## **Planning Act 2008 (as amended) – Section 51**

### **Application by Total Energies and Corio Generation for an Order Granting Development Consent for the Outer Dowsing Offshore Wind (Generating Station) (EN010130)**

#### **Advice following issue of decision to accept the application for examination**

2.2 Works Plan Offshore V4

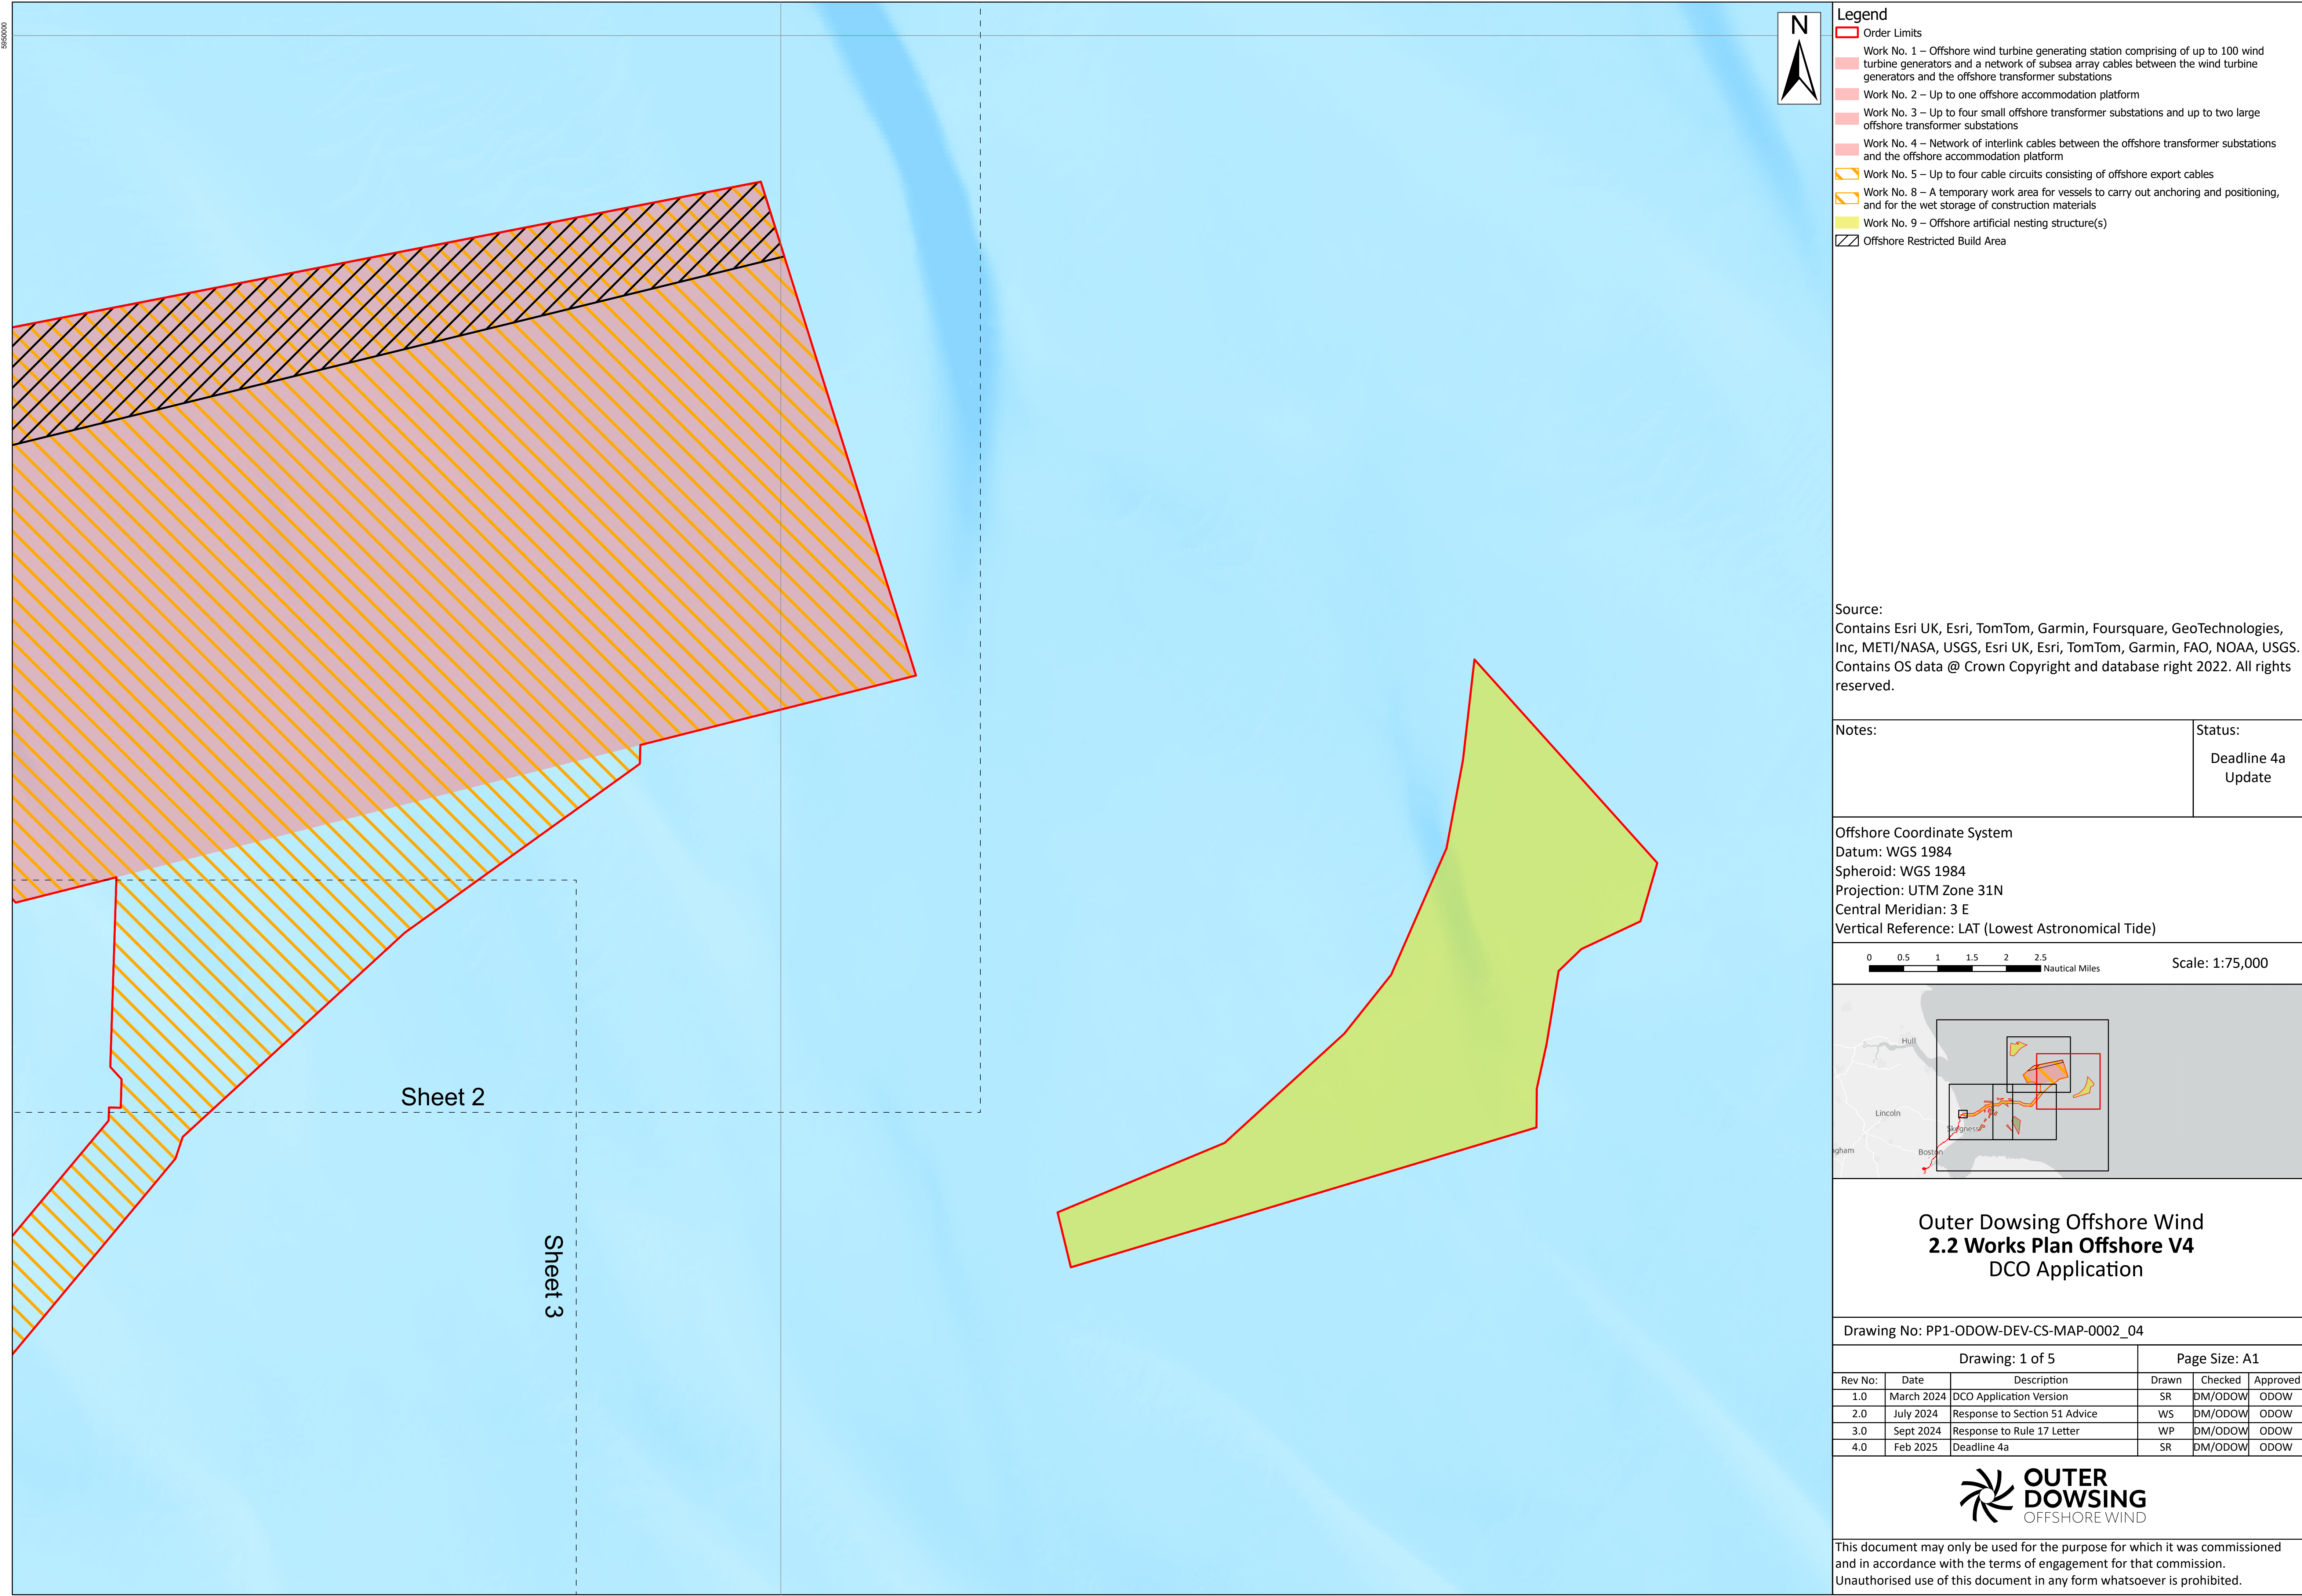
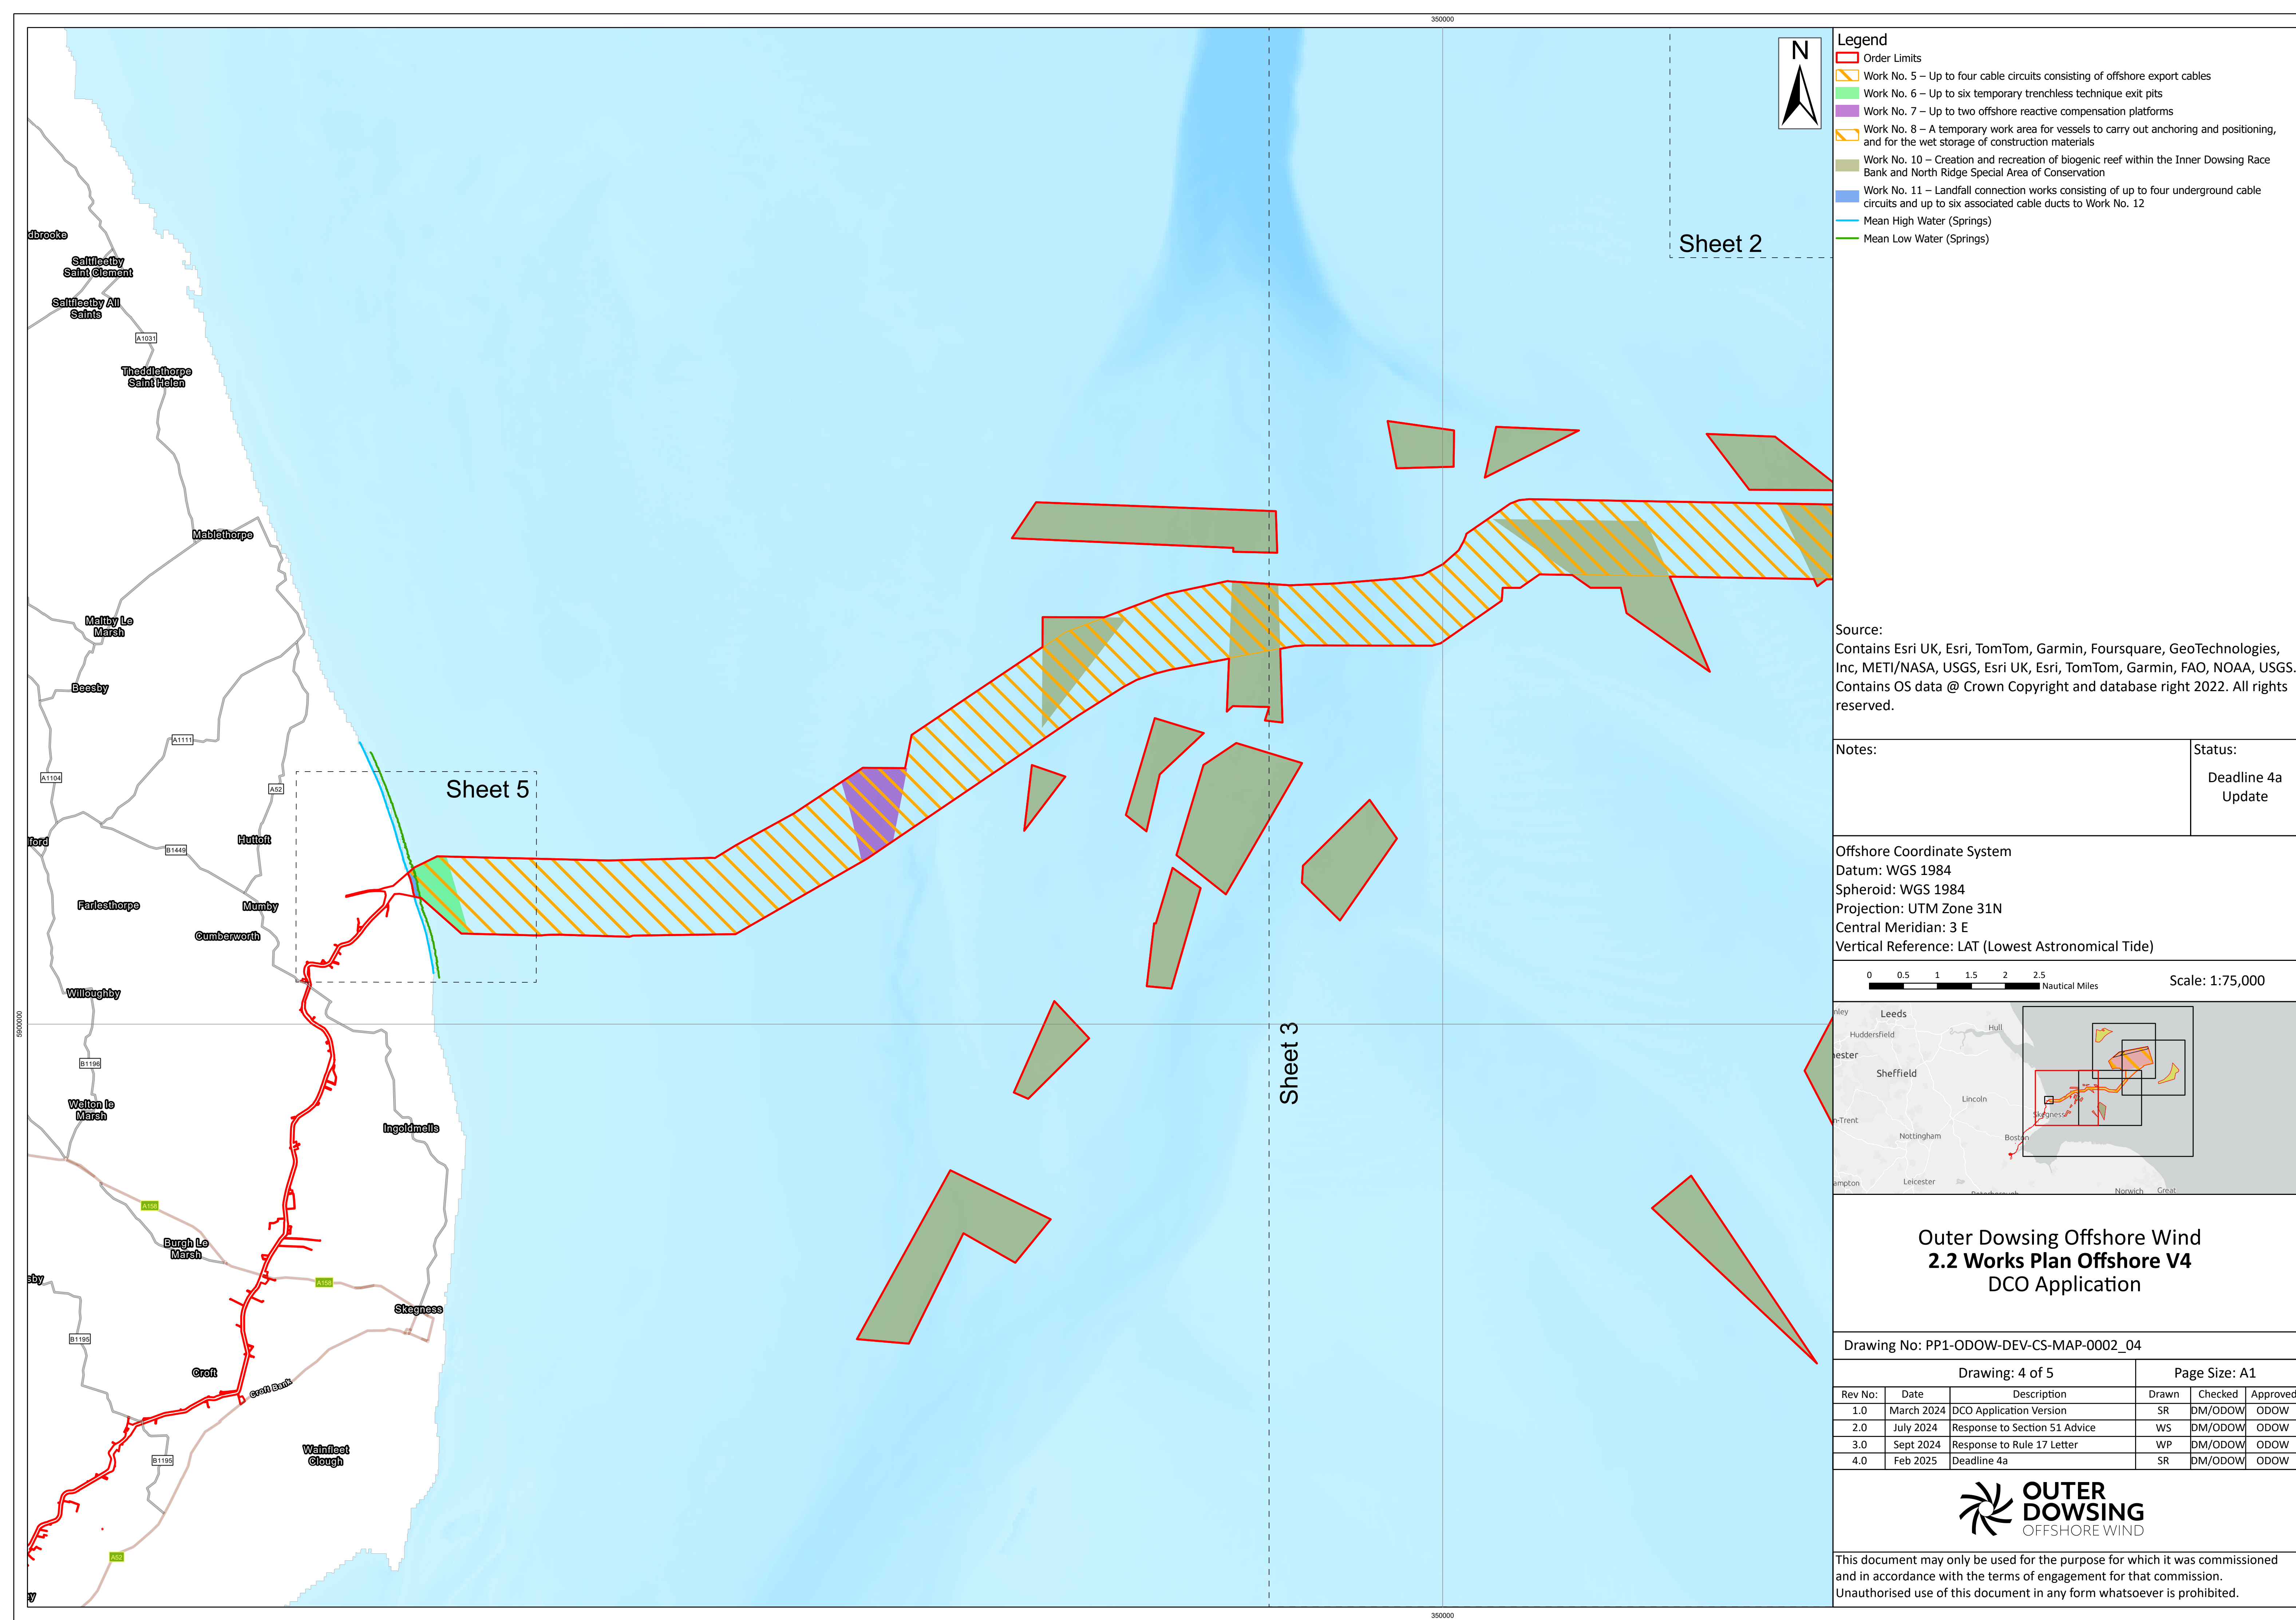
- **Onshore Works Plans** (Doc 2.1)
  - Ensure consistency between colours used in the Legend e.g., yellow colour is bright on legend but appears dull on plan.
- **Offshore Works Plans** (Doc 2.2)
  - Ensure consistency between colours used in the Legend e.g., green colour is bright on legend but appears dull on plan.

- Legend of works does not fully match dDCO works as described, for example the legend description for works no 7 mentions HVAC however the work as described in dDCO does not mention HVAC.

- Labelling of identifiers used are obscured or not easily identifiable, for example Inner Dowsing Race Bank and North Ridge Special Area of Conservation (SAC) are not shown on the plan.
